From: Emma Patchell [REDACTED]
Sent: 17 September 2018 16:01
To: Anita Gardner
Cc: Mark Warwick; Anna Gillings
Subject: FW: A/23/18/DOC - Broadlees, Dappers Lane, Angmering

From: Mark Warwick
Sent: 05 September 2018 17:12
To: Anita Gardner
Subject: A/23/18/DOC - Broadlees, Dappers Lane, Angmering

2. Ground Protection as shown in Plan 3A is absent at the NW corner of the site. Again, there are trees of value here at least one of which appears to be the subject of an Order (TPO). This needs to be in place before I am comfortable that any demolition work can proceed.

TREE PROTECTION (Plan 3A)

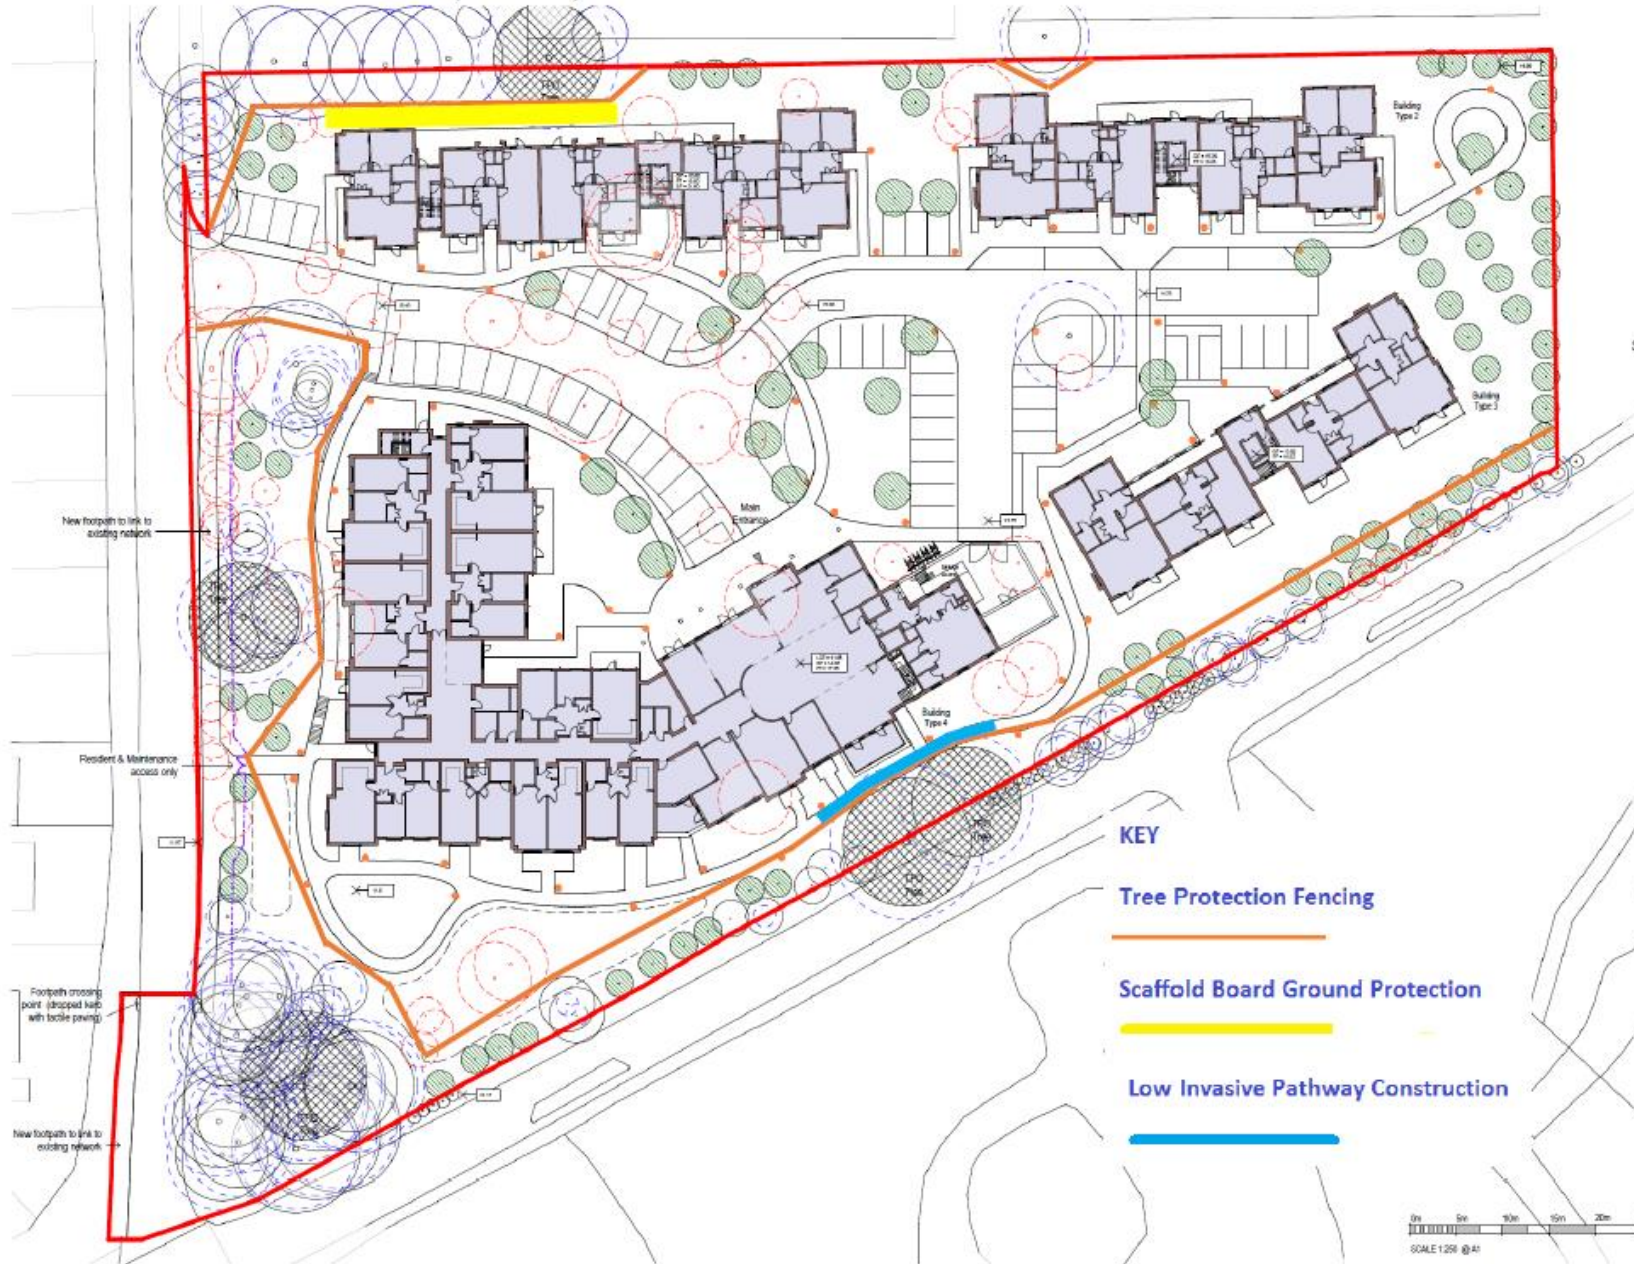
1. There is a gap in the fencing (mesh panel required) which permits access to trees, at least one of which appears to be the subject of an Order (TPO). This needs to be secured so as to

The details required from Mark requested that a gap in the fencing is fixed and that the ground protection area shown in plan 3A to be put into place to the NW corner. I am pleased to advise that this has now taken place and both measures are now on site. Please see the photos below to confirm this.
